Consultation Response from KC, Lead Local Flood Authority		
2020/91896 Pentlands, New Mill Road, Holmfirth, HD9 7LN		
Demolition of existing dwelling and erection of 17 dwellings with associated access and external works		
Date Responded: 3rd March 2021	Responding Officer: Paul Farndale	Responding Ref:

PROJECT TITLE		NEW MILL ROAD	
DRAWING TITLE		PROPOSED SITE PLAN	
SCALE	DRAWN	CHECKED	PROJECT REFERENCE
1:200	JH	JH	ODS-19-77
PAPER SIZE	DWG NUMBER	DATE	REVISION
A1	(20)001	22/1/20	J
CLIENT		PRIESTROYD CONSTRUCTION

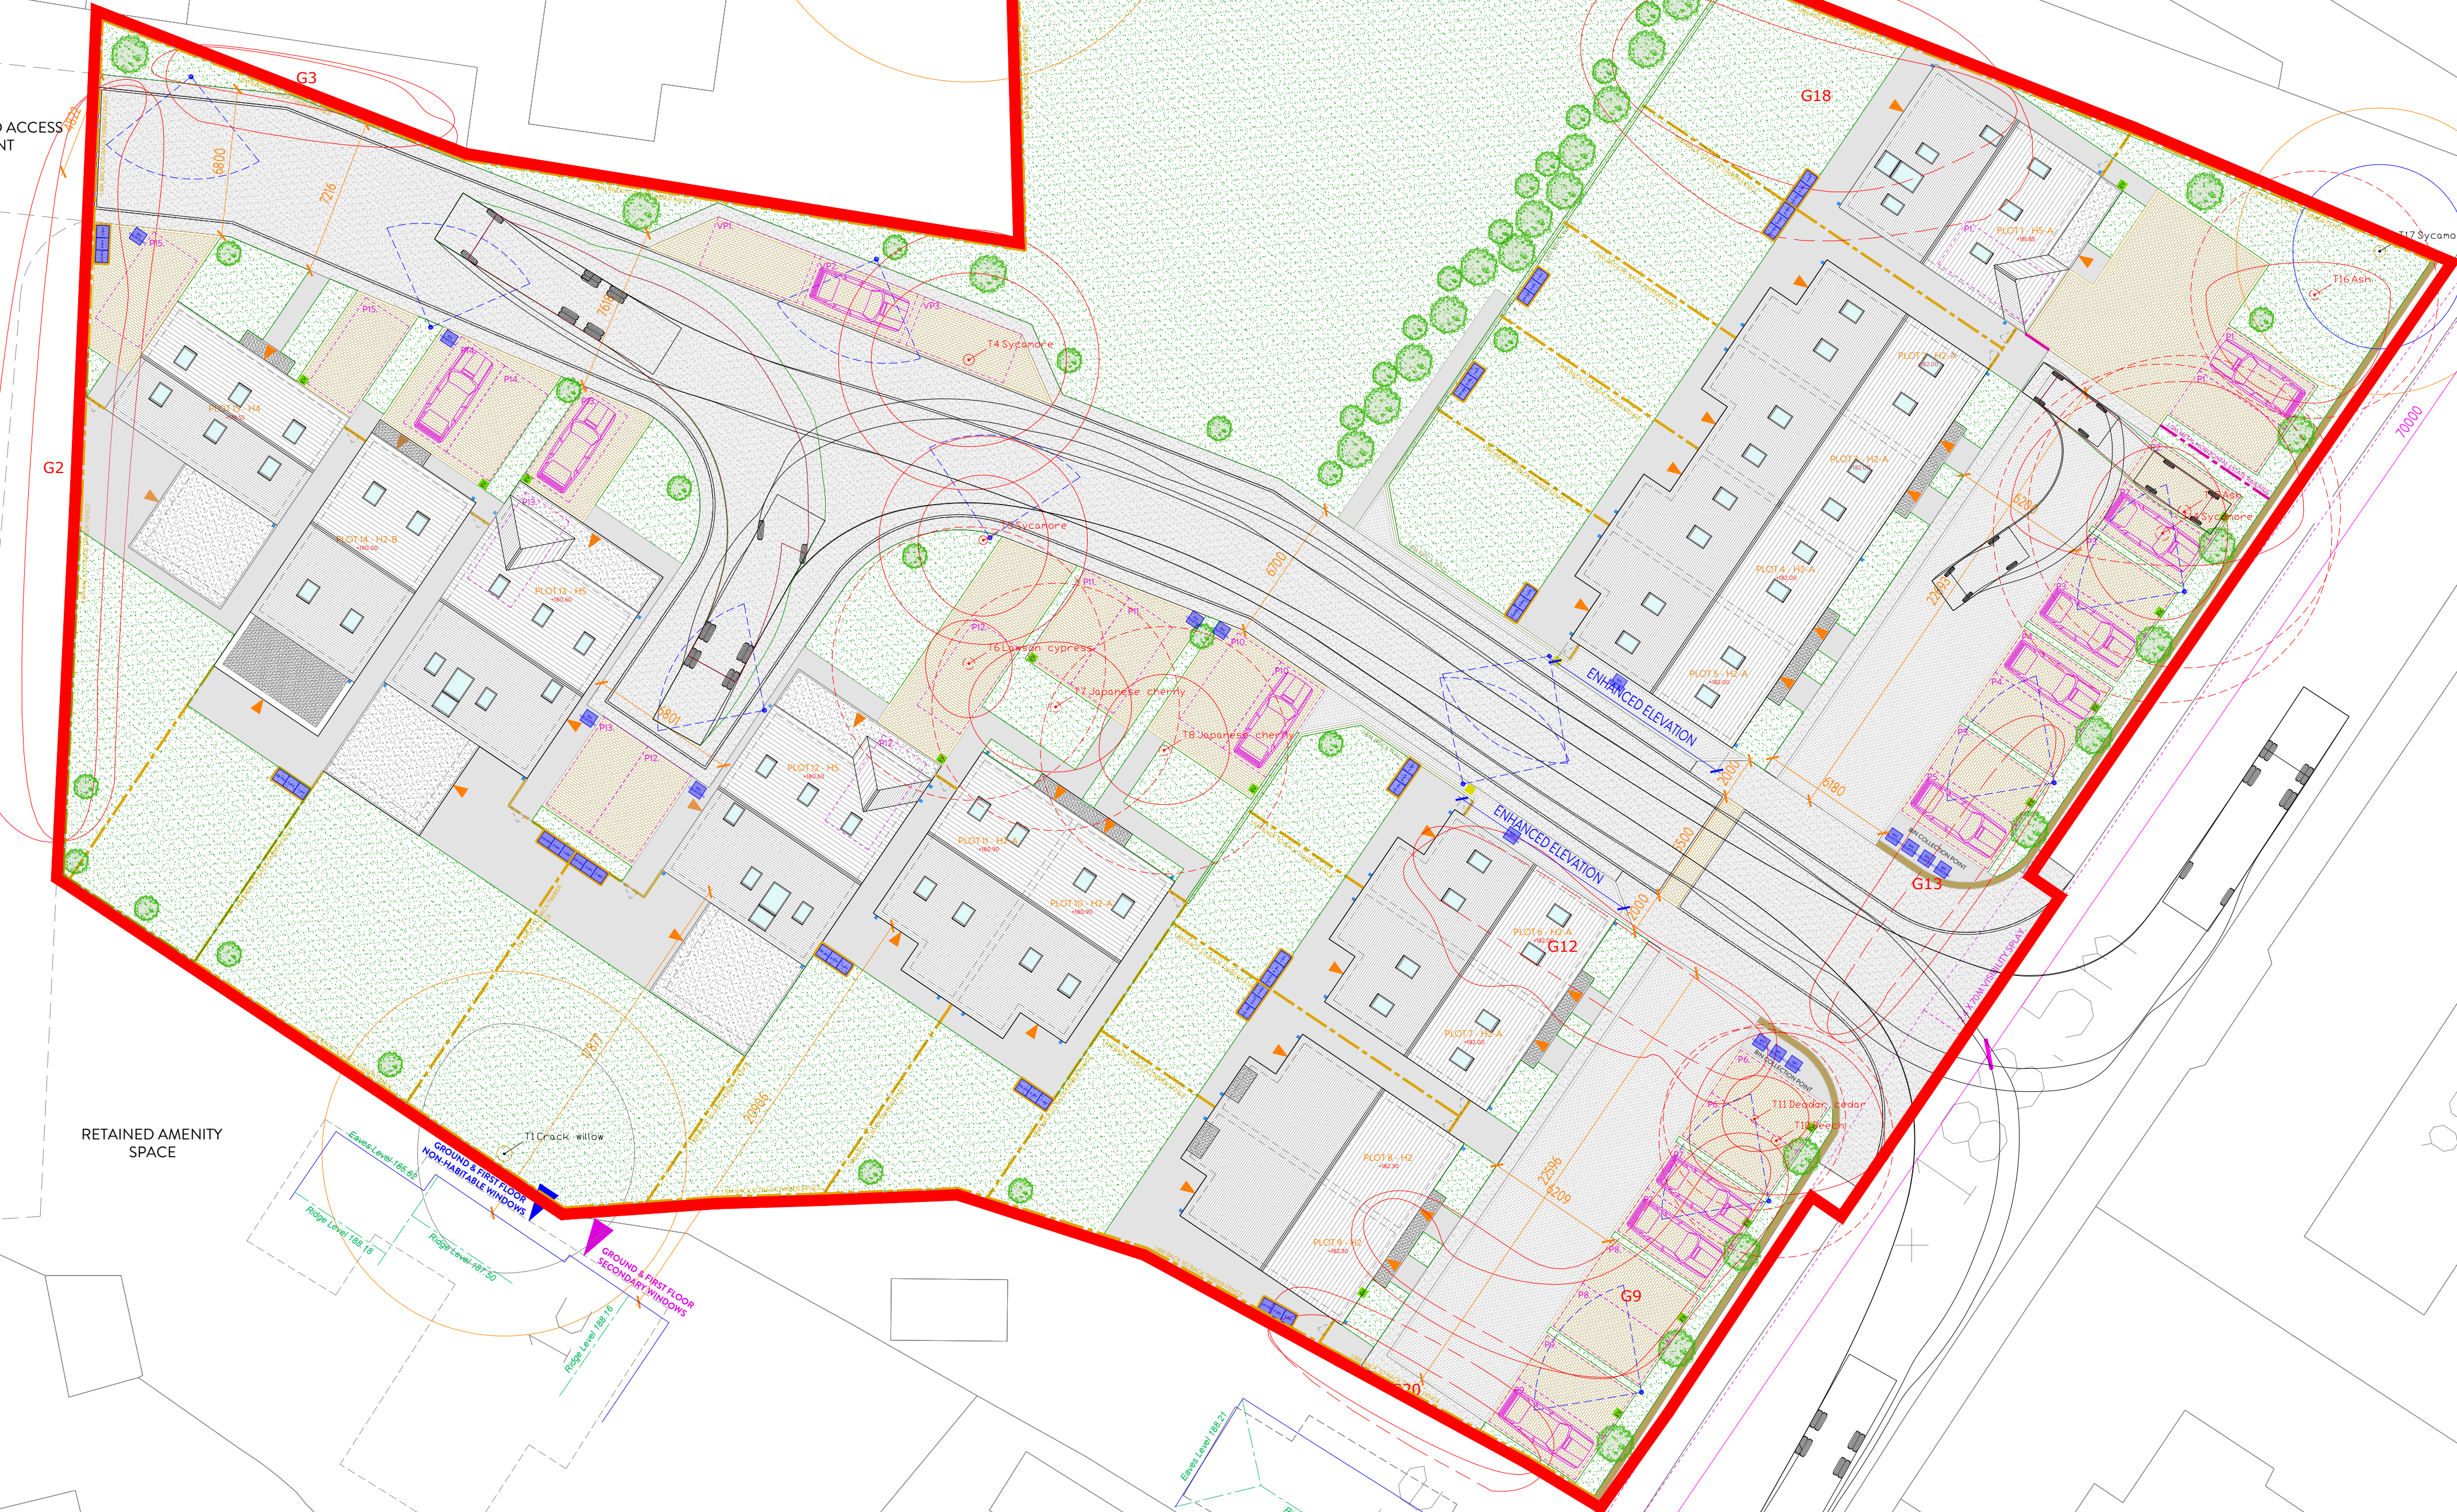
- Flood routing shows indicative arrows and it is not clear whether rainwater running overland due to blocked gullies or exceedance events will flow into site from New Mill Road or not.
- Level information is limited, and the indicative arrows do not emphasise whether these overland flows come off the site's spine road and down one of the lateral roads, as opposed to down the spine road and the site avoiding curtilage which is a pre-requisite for removing our objections.

No updated drainage plan showing connection points and levels into the Midlothian Garage development including the drainage of existing property Glen View has been submitted. It is unclear therefore if space has been made for water in terms of attenuation requirements or foul pump station stand offs using the submitted revised layout.
